The reference numbers used are from the document ExQ2

4.1 the applicant recites the Holford rule 3 - where possible choose inconspicuous locations for angle towers, terminal towers and sealing end compounds. Options 1 and 2 put forward both do this but option 2 is more compliant than option 1. It is agreed that option 2 has 2 more angle towers than the NG proposal however one of them is in the sealing end compound and the other one is only a very slight angle. Both of which are in inconspicuous locations and only really seen by the landowner. The decision to proceed with their proposal is as already stated an economic one which NG as pointed out at the hearing are bound to take but the economic effect on the landowner must have some effect on the decision making process.

NATIONAL GRID (YORKSHIRE GREEN ENERGY ENABLEMENT PROJECT)
 ILLUSTRATIVE PLAN: ACCESS DURING CONSTRUCTION PHASE - SHIPTON
 REGULATION 5(2)(o)
 SHEET 1 OF 2

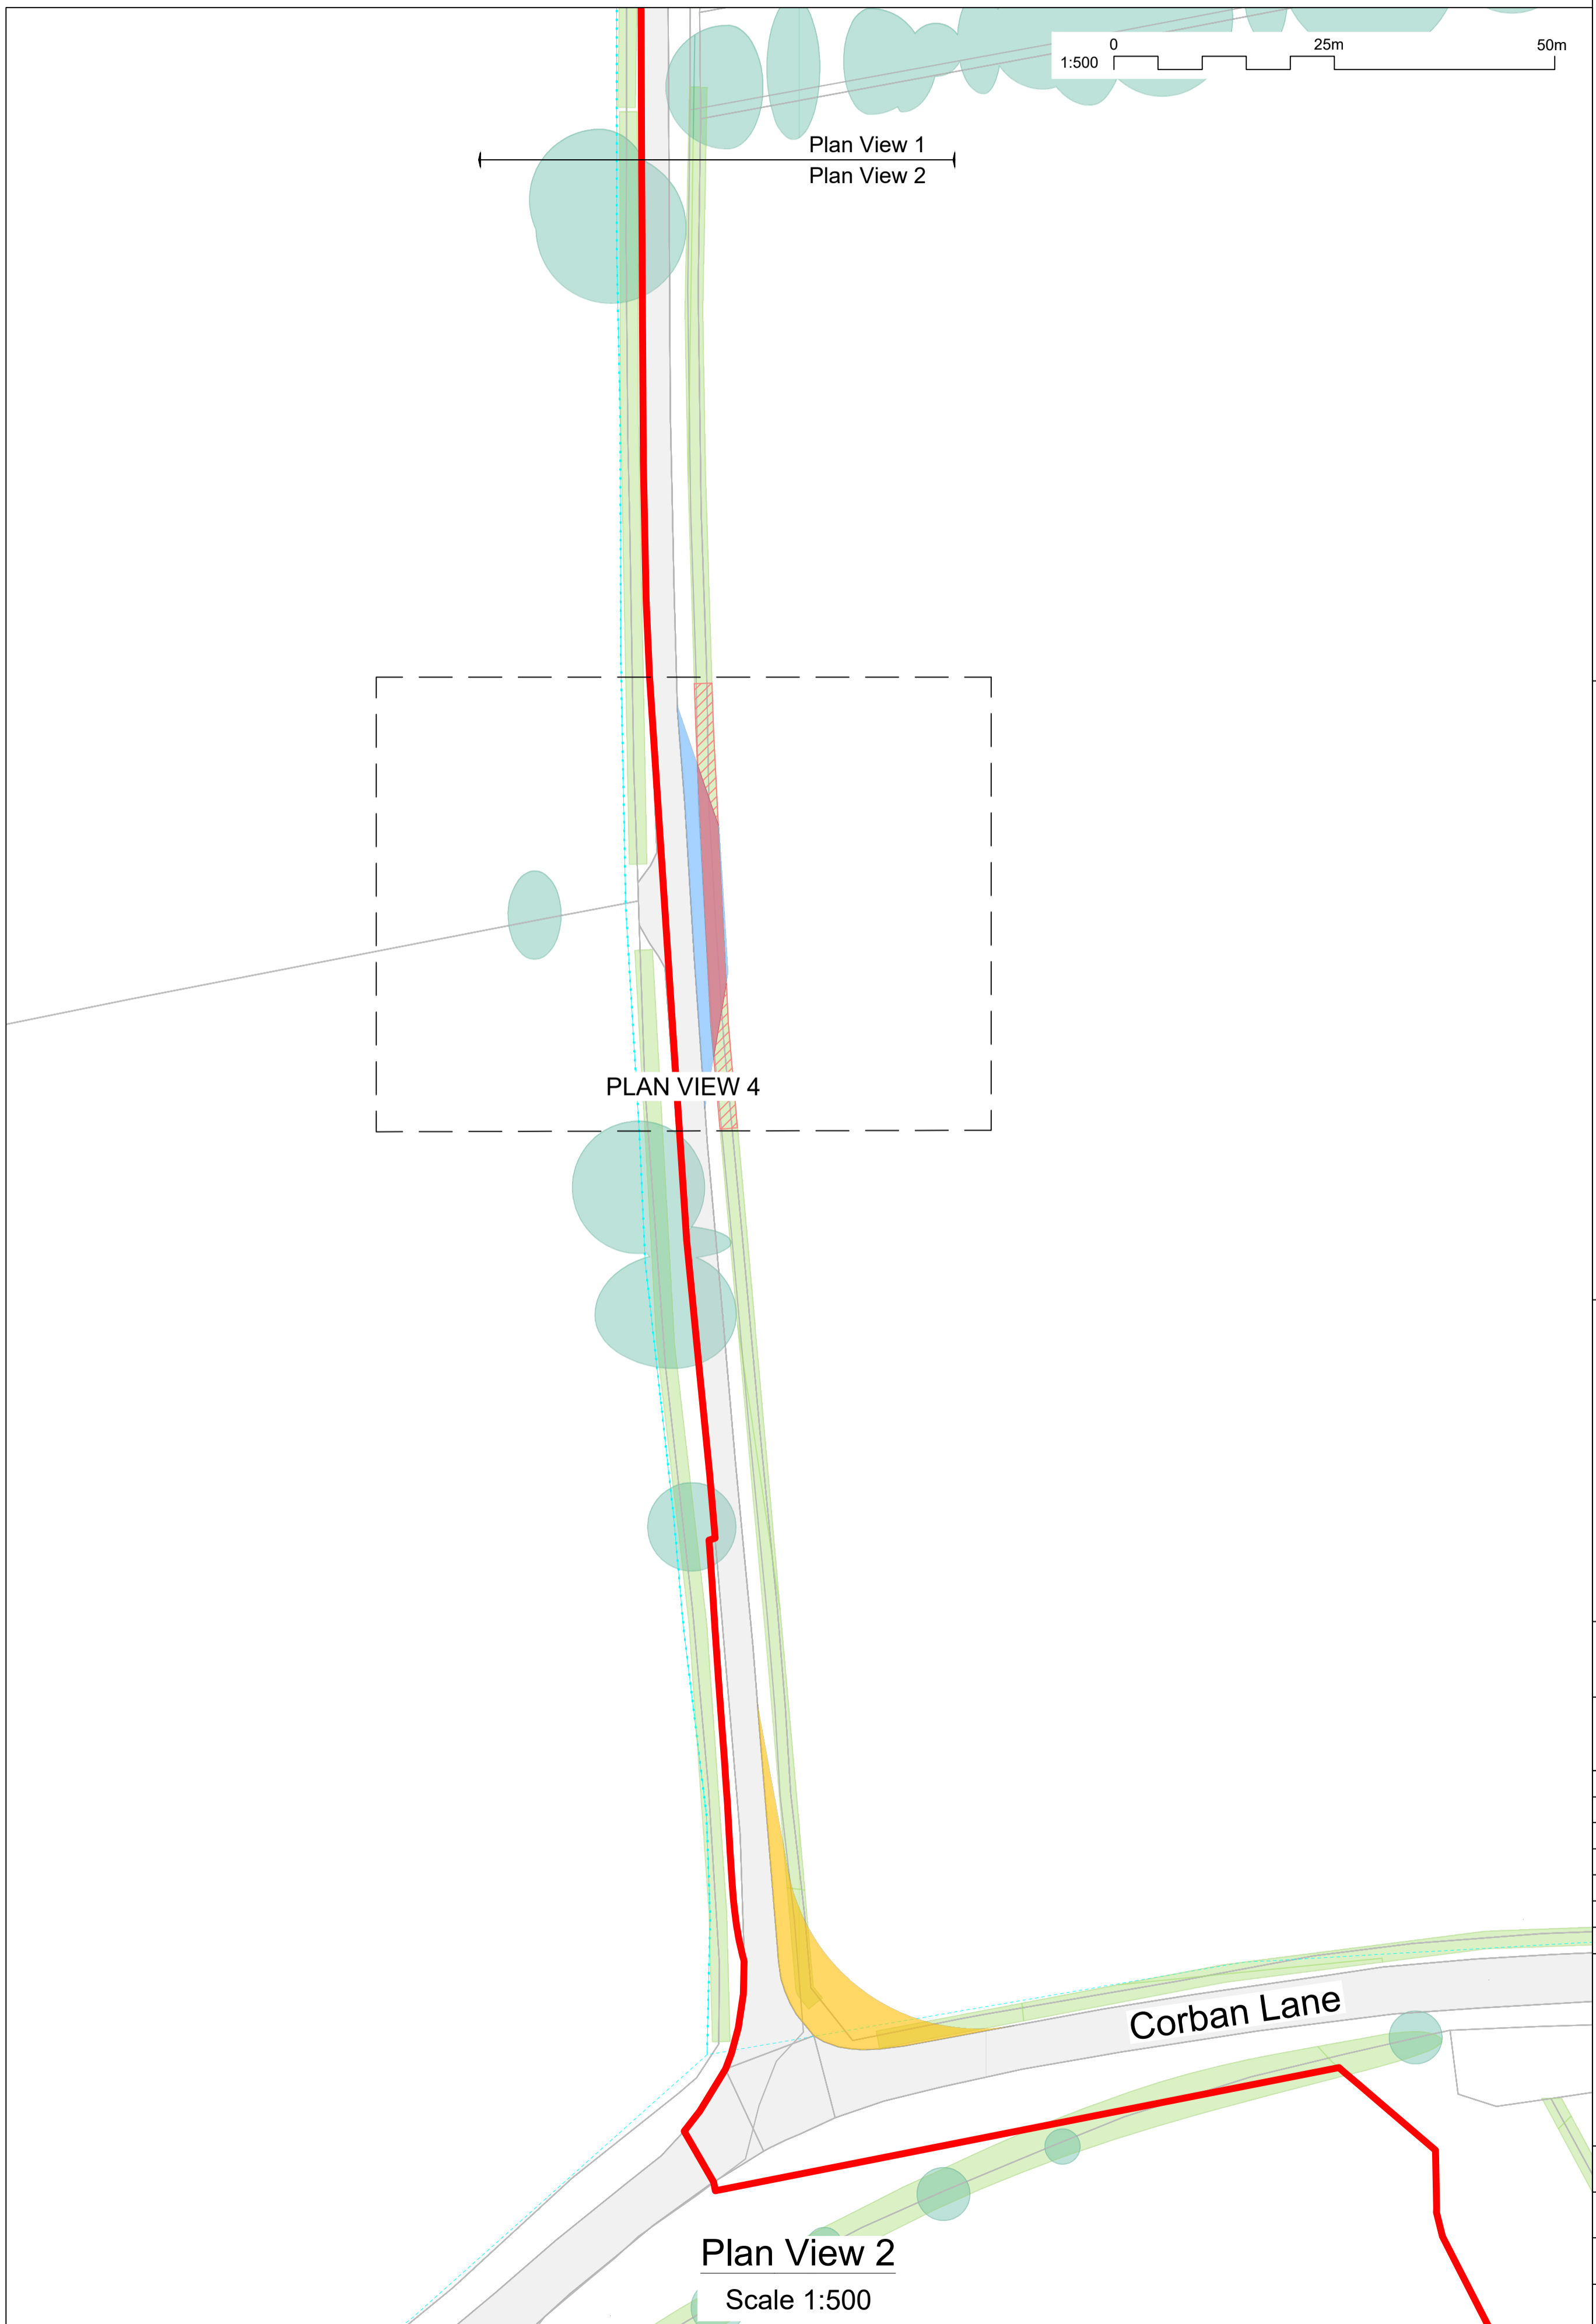
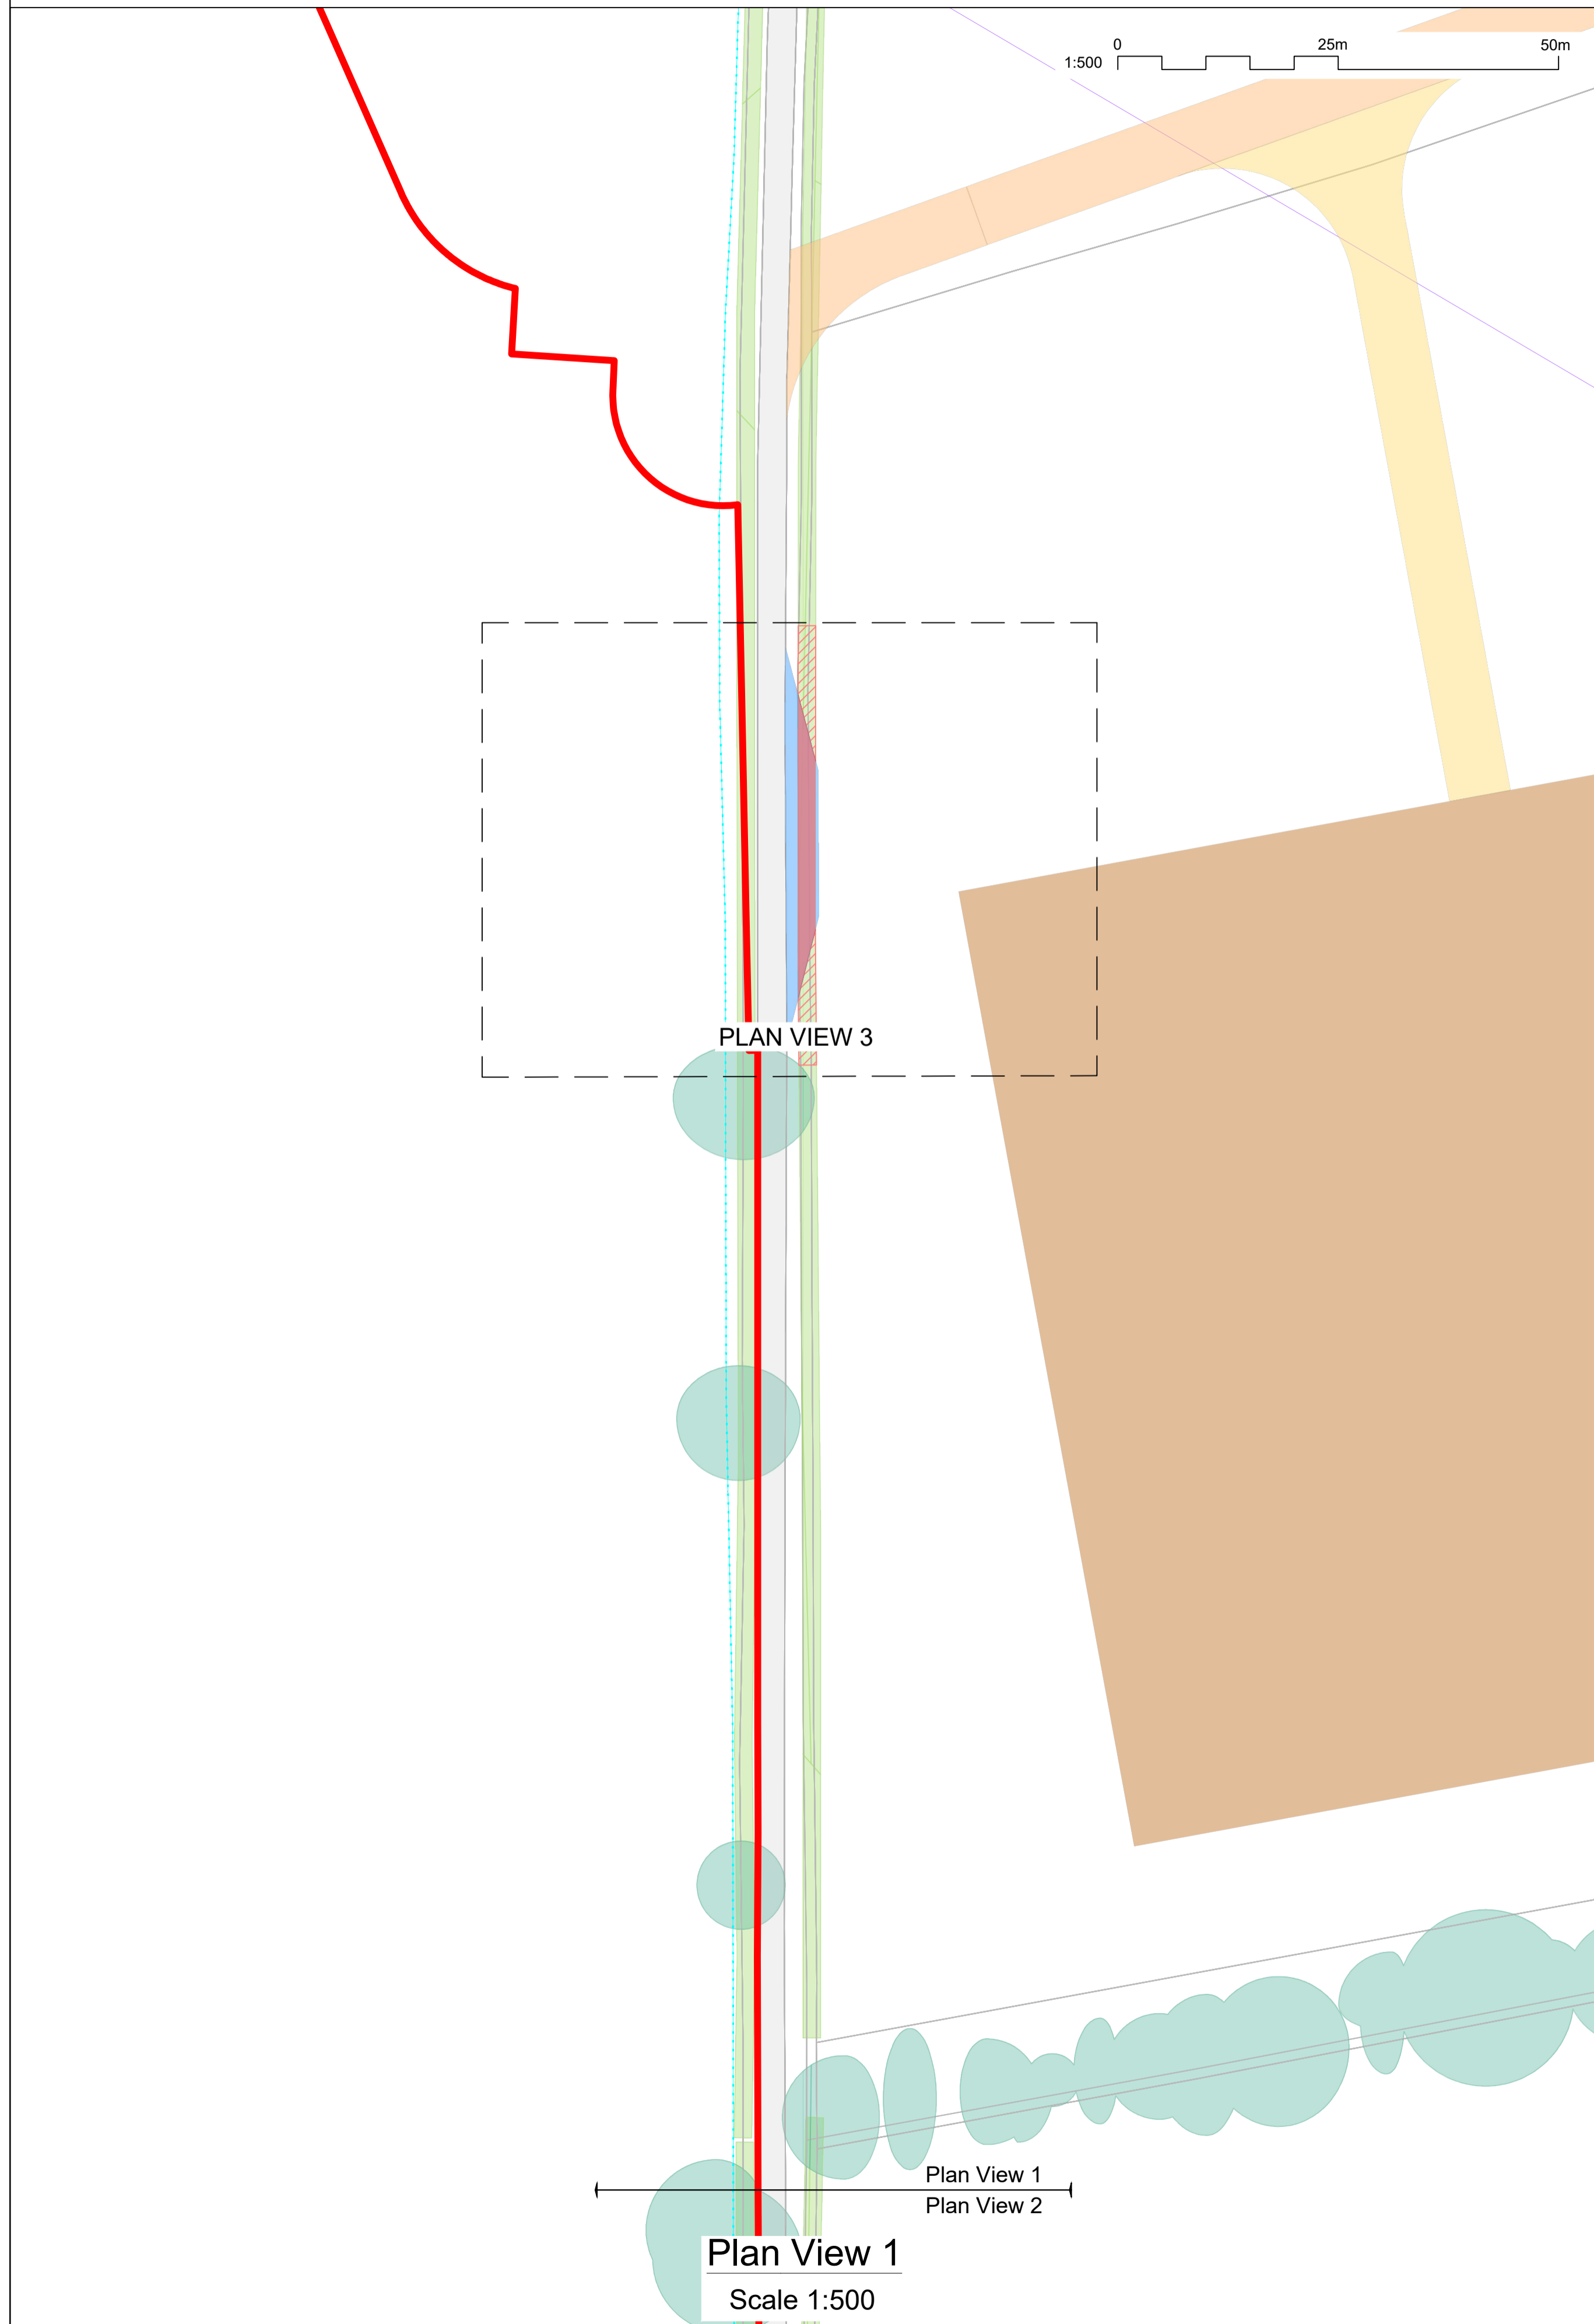
discussions are on going between the parties in the light of the proposed change to the permanent access route to the sealing end compounds. However the proposed location of the 2 passing places on Newlands Lane was received from NG last week - this propose to remove in total 100m of strong mature thorn hedge which is circa 7-8 feet tall, there has been no proposal put forward as to how the construction traffic will be managed. On boundary between the 2 compounds there is a dead oak tree and with some crown pruning an gap can be made in this location to allow construction traffic to pass unhindered and safely through to the sealing end compounds. This is a matter for further discussion with NG.
